19 March 2015

RE: Assessment of Impact on Remediation Plan from Proposed Modifications to Excavation Plan for North West Plot - Darling Square, Haymarket, Sydney

LLD's requested Coffey Environments Australia Pty Ltd (Coffey) to provide an expert opinion on the potential impact from the proposed modifications on the Remedial Action Plan (RAP):

**DEVELOPMENT APPLICATION**  
**NORTH WEST PLOT**  
**DETAILED EXCAVATION**

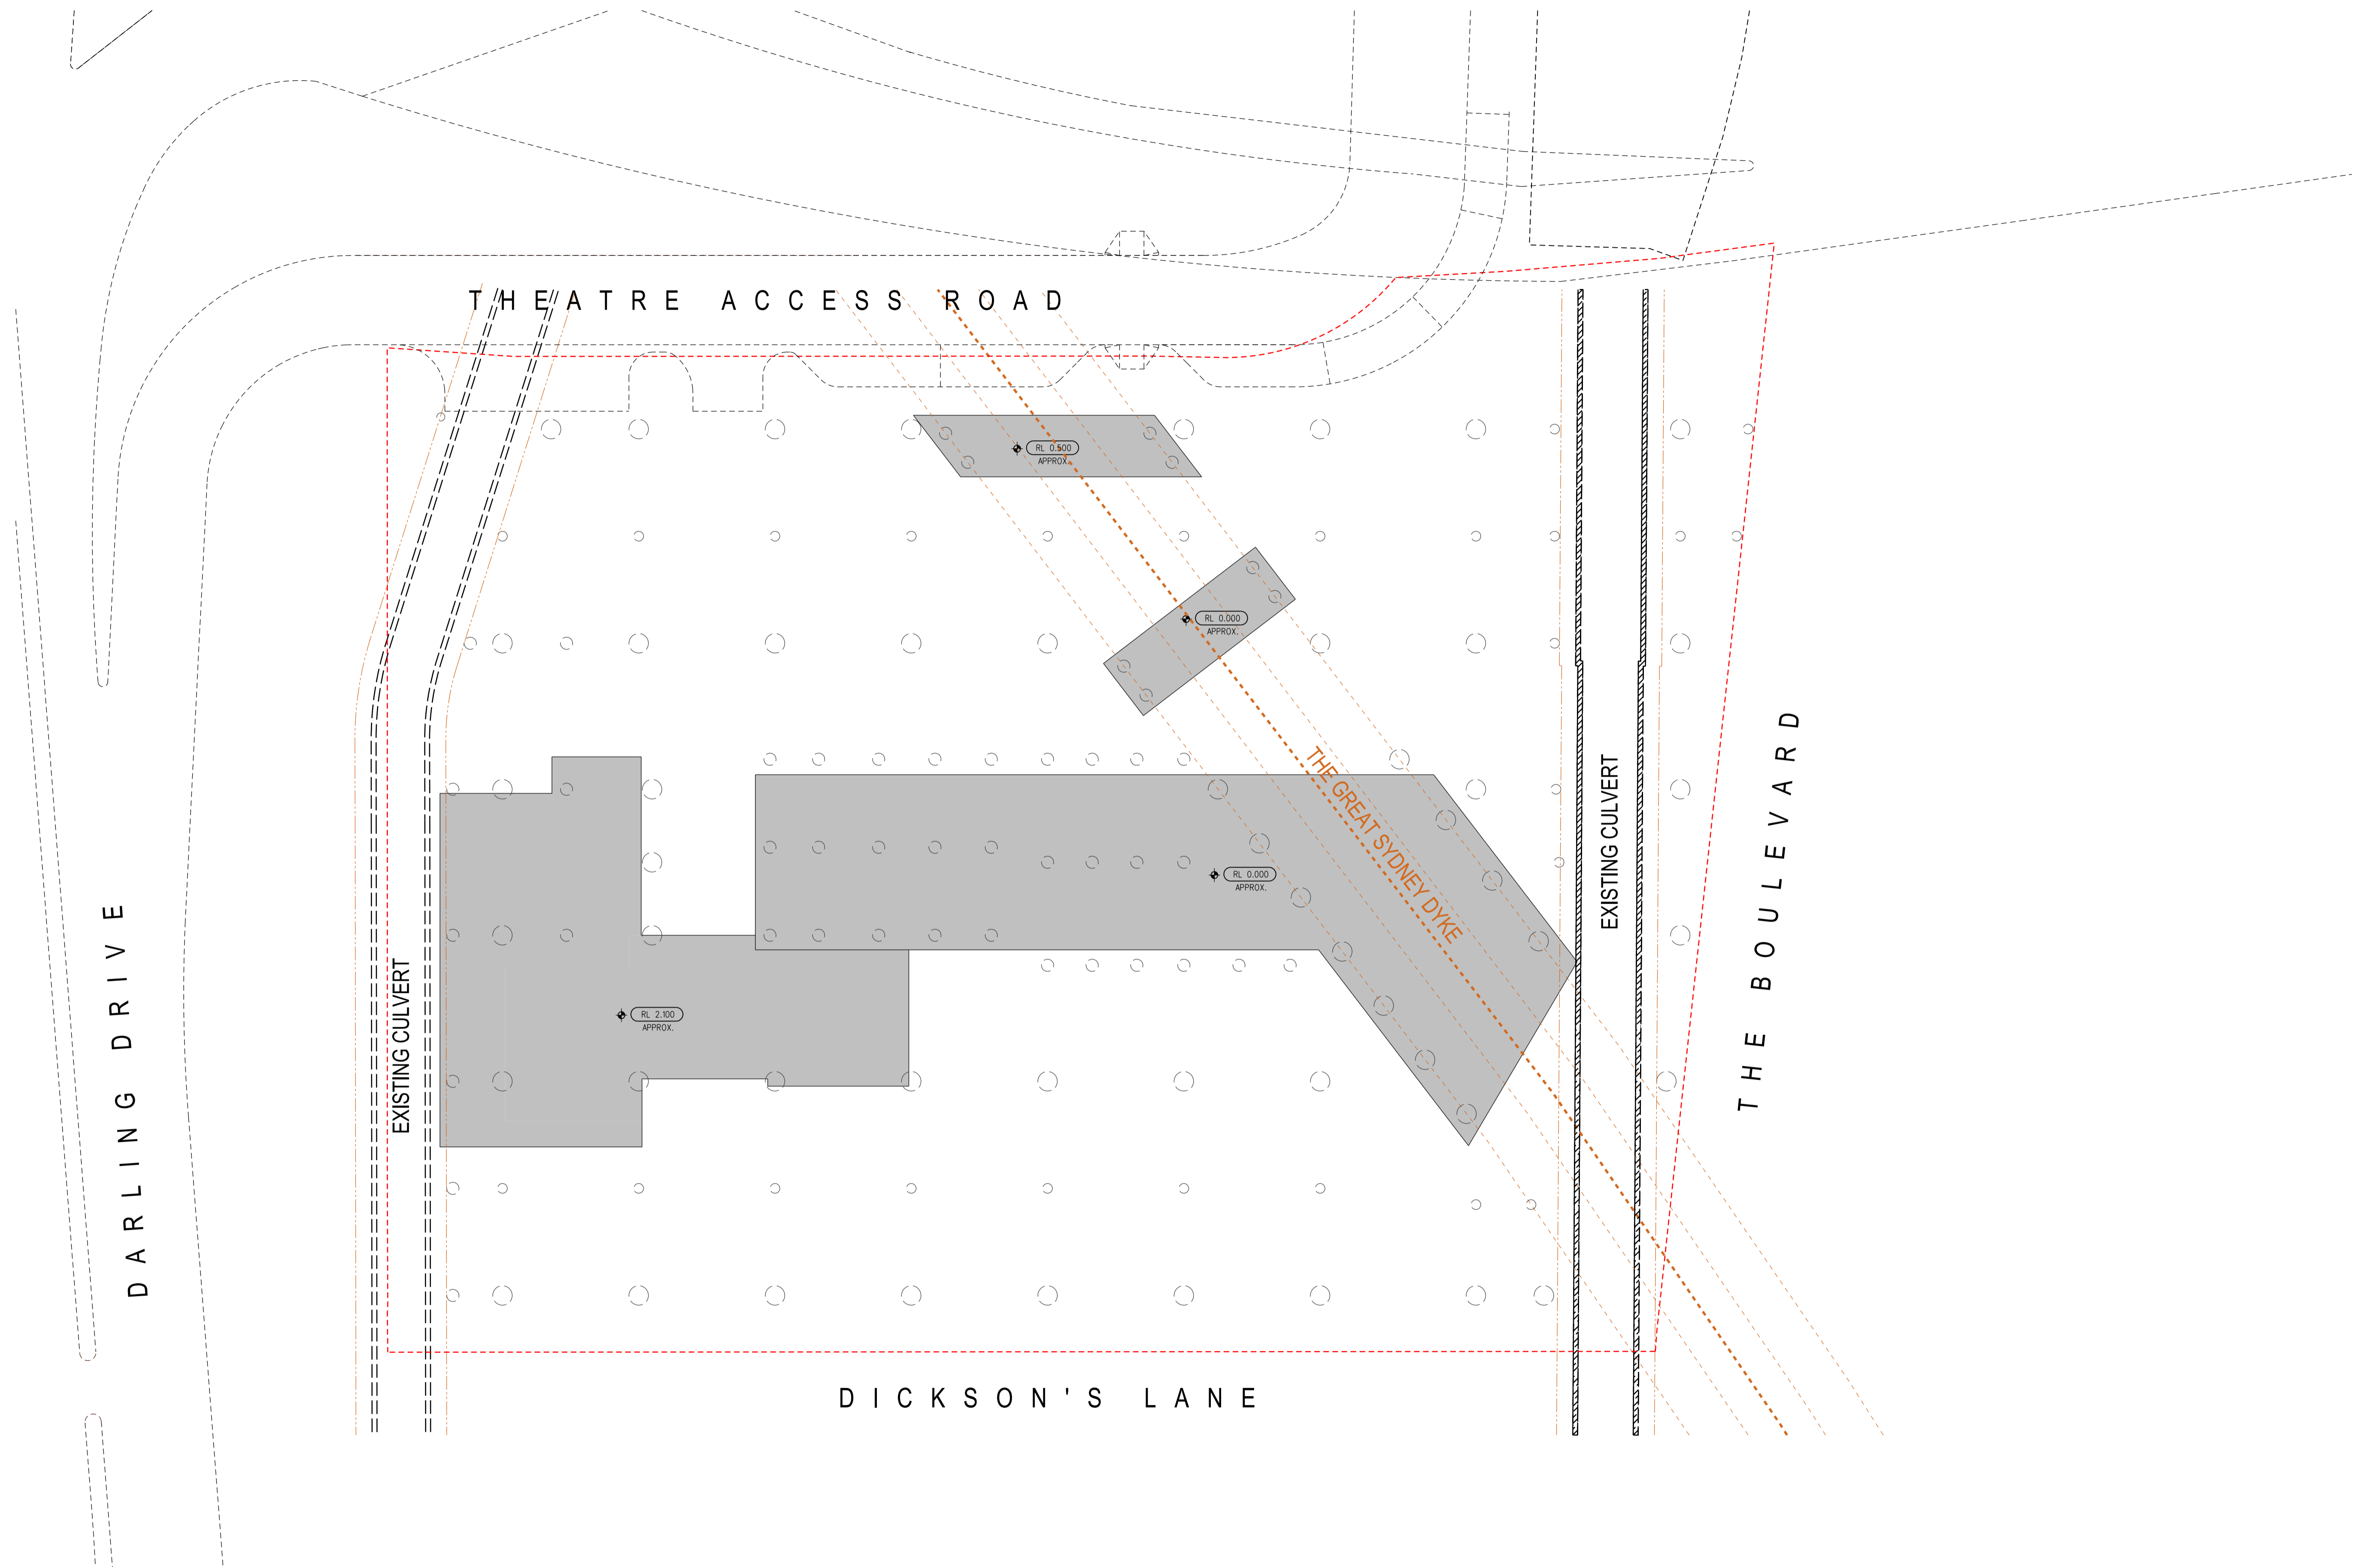
The additional excavations noted under Item (d) above have the potential to alter contaminant exposure pathways during construction, and possibly for future ground level uses of the North West Plot. LLD indicated that the purpose of additional excavations is to accommodate the added lift pits and below ground water storage in areas shown on Wooda Bagot Drawing No. DA1000 entitled '*Detailed Excavation*' dated 10th March 2015 (Refer Attachment 1). Coffey understands that the grey shaded areas in this sketch represent the extent of development excavations anticipated under Modification Application. For comparison, Coffey has enclosed a copy of the Drawing No. SNW_DA30006 '*Development Application NW Plot – Detailed Excavation*' (Rev.02; dated 24th Jan 2014) in Attachment 1 which illustrates the extent of excavation anticipated under the existing consent.

LLD expects that these additional excavations are unlikely to extend lower than RL0.0, which is 3m below ground floor level and approximately at the top of the groundwater table but not intersecting natural alluvium.

- The northernmost additional excavation area appears to be positioned over current Remediation Area 1. The preferred option to remediate Area 1 is hazard removal with disposal of impacted soils to an appropriately licensed landfill. The procedures set out in Section 10.8 and Section 11 would apply in remediating and validating known areas of contamination, which can be reasonably expected to be encountered during excavation.

- The RAP was developed with an understanding that localised shallow excavations above the groundwater table would be required to accommodate lift shafts and other below ground utility infrastructure. Section E7 (in Appendix E to the RAP) provides a specific discussion of the remediation action and management of materials from the development of the North West Plot.

Based on the extent of additional excavation proposed, Coffey considers that the modifications do not warrant amendment of the RAP because:

In conclusion, Coffey confirms that the proposed modifications are consistent with the land uses adopted during the preparation of the RAP. Coffey considers that the additional shallow excavations to accommodate lift wells and for harvested water storage was generally addressed in the RAP and that the overlap of any proposed excavation area with Remediation Area 1 does not require change to the RAP.
